Your ref: 2020/60/92331/E

Date: 24 February 2021

**Wakefield Council Consultation Response - 2020/60/92331/E Land east of, Leeds Road, Chidswell, Shaw Cross, Dewsbury**

Client:	The Church Commissioners	Job No:	18,006
Project:	Chidswell Masterplan		
Title:	Parameter Plan - Access		
Date:	10/04/19	Scale:	As indicated
Drawing No:	00-205	Drawn By:	BBA1
		Checked by:	RG
		Revision:	E

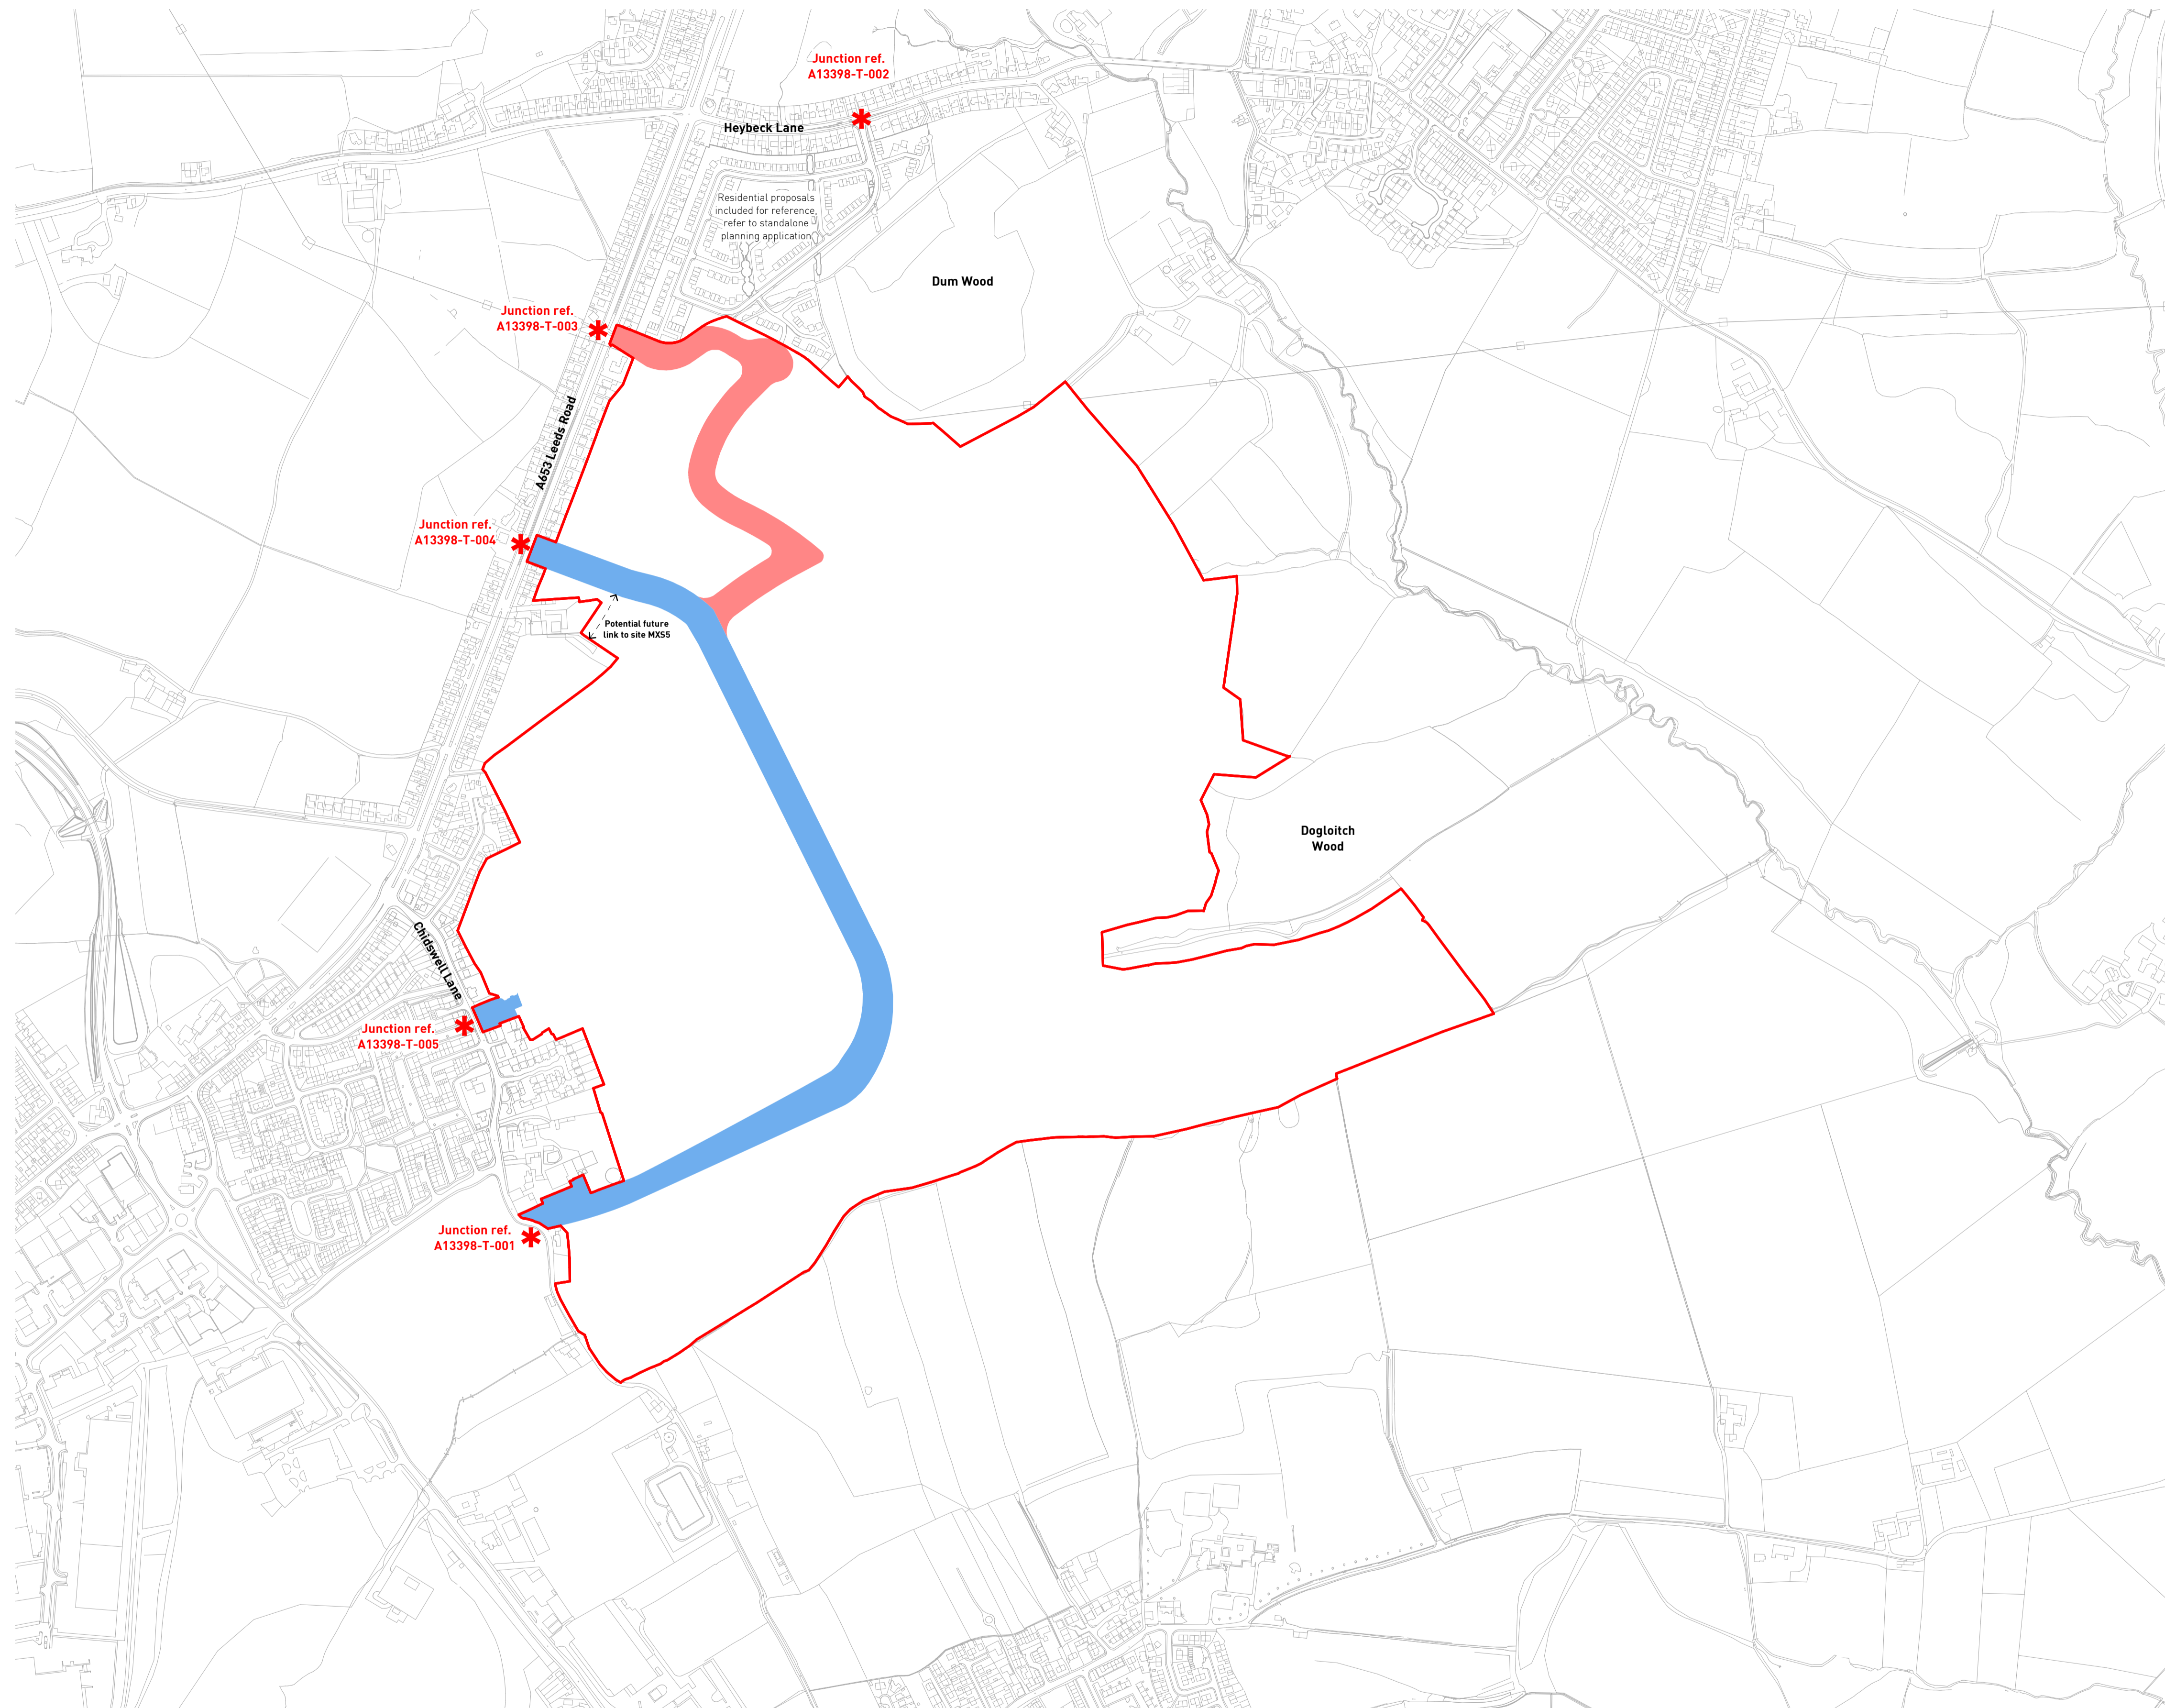
- Wakefield Council is inclined to agree the proposal to remove the direct route from Leeds Road (via the proposed closure of Chidswell Lane to the north of the spine road) will make the present movement from Leeds Road to Gawthorpe significantly less attractive to road users;

- The signage and alignment of the junction in drawings Wakefield Council have seen proposed at the northern end of Chidswell Lane, will further add to making it unattractive for those inclined to "rat-run", from north to south along Chidswell Lane, joining Owl Lane just to the west of Gawthorpe. At that point, drivers would simply have to wait for a break in the heavy (peak) traffic flows on Owl Lane from development generated traffic that joined Owl Lane from the new roundabout junction;

As such, Wakefield Council considers it essential the spine road through HS47 and new roundabout on Owl Lane are secured and Chidswell Lane is stopped up, just to the north of

where the spine road will cross it to access MXS7 when construction commences on that site. These essential highways improvements should be secured through planning conditions and / or section 106 agreements as appropriate. These interventions may be adequate to outweigh the conflict with the site policy for MXS7 identified above.
